Application Ref:	3/2026/0385			 Ribble Valley Borough Council www.ribblevalley.gov.uk
Date Inspected:	19/06/26	Site Notice:	19/06/26	
Officer:	AR			
DELEGATED ITEM FILE REPORT:				APPROVAL

Development Description:	Proposed demolition of rear extension, erection of a single storey side and rear extension.
Site Address/Location:	18 Chesterbrook Ribchester PR3 3XT

**7425 - E01** Rev B

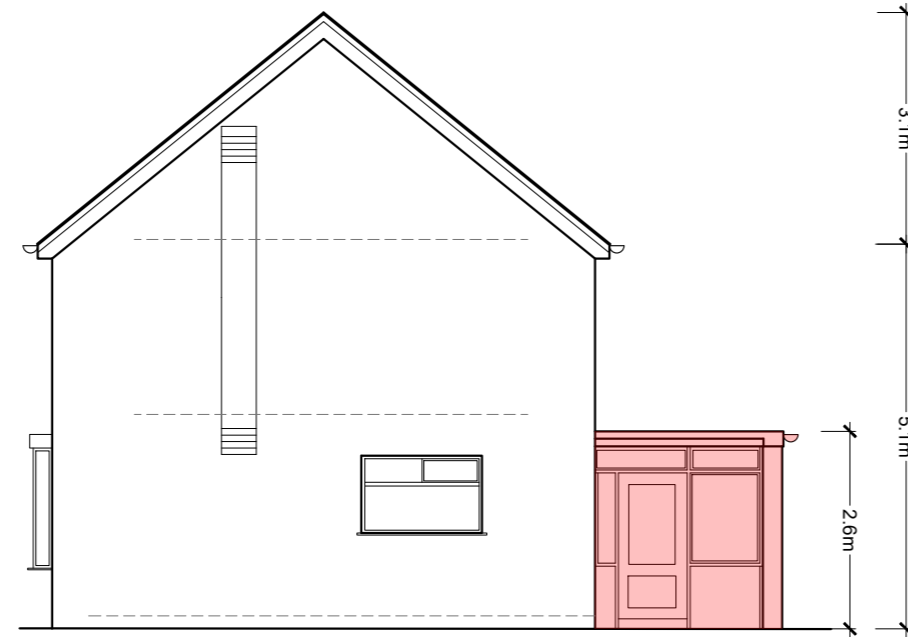
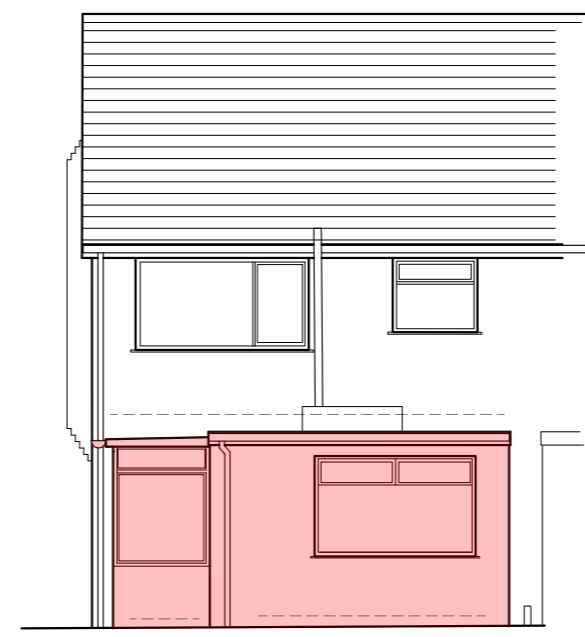
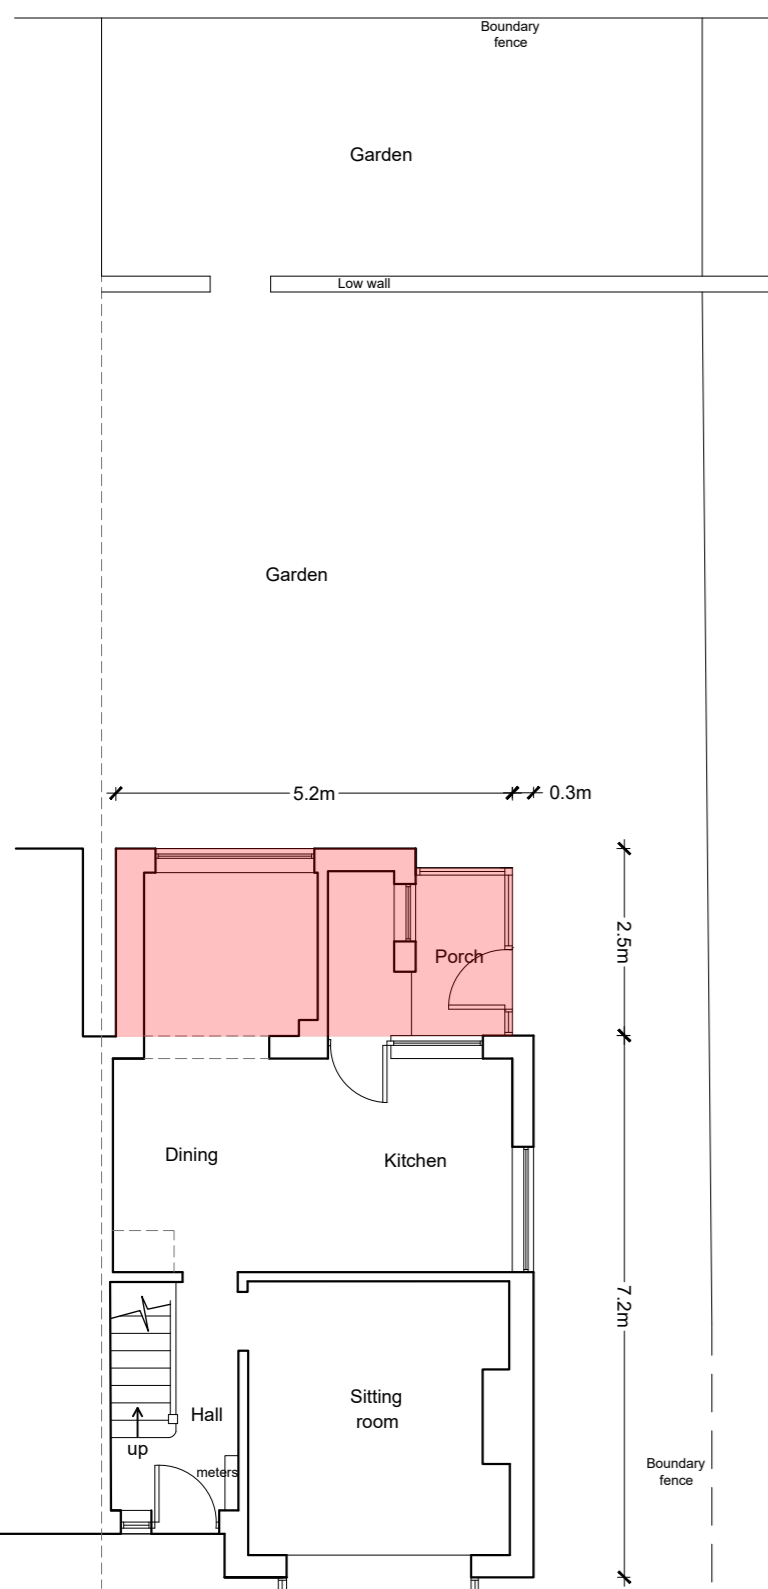
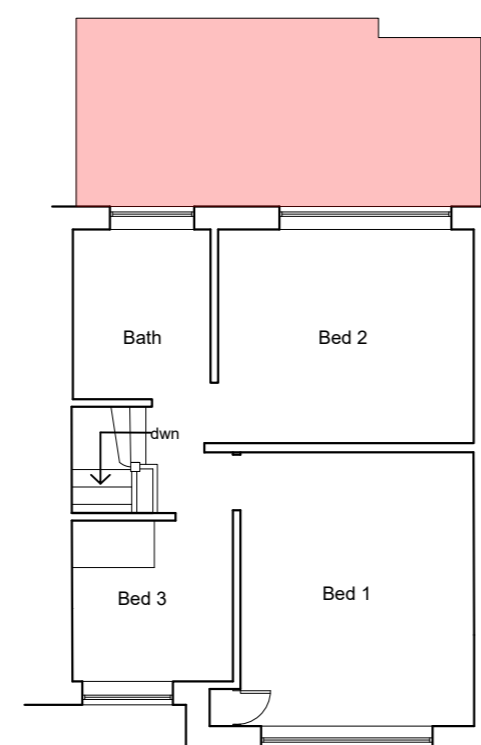
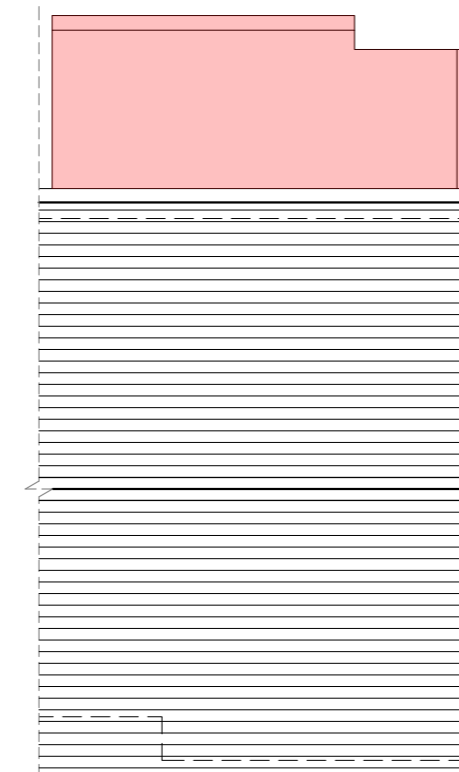
Following a desktop analysis and an on-site inspection, it was determined that the following plans are inaccurate and potentially misleading, as they do not depict the existing garage:

- Existing Floor Plans, Roof Plan and Elevations, ref: 7425 – E01, revision B
- Existing and Proposed Site Plans, ref: 7425 – P04

The agent has confirmed that the existing garage was not shown on the drawings because it was scheduled for demolition. While the submitted drawings should have referenced the existing garage at the time of application, the planning officer has accepted that, following the submission of photographic evidence on 21 July, the garage has now been demolished.
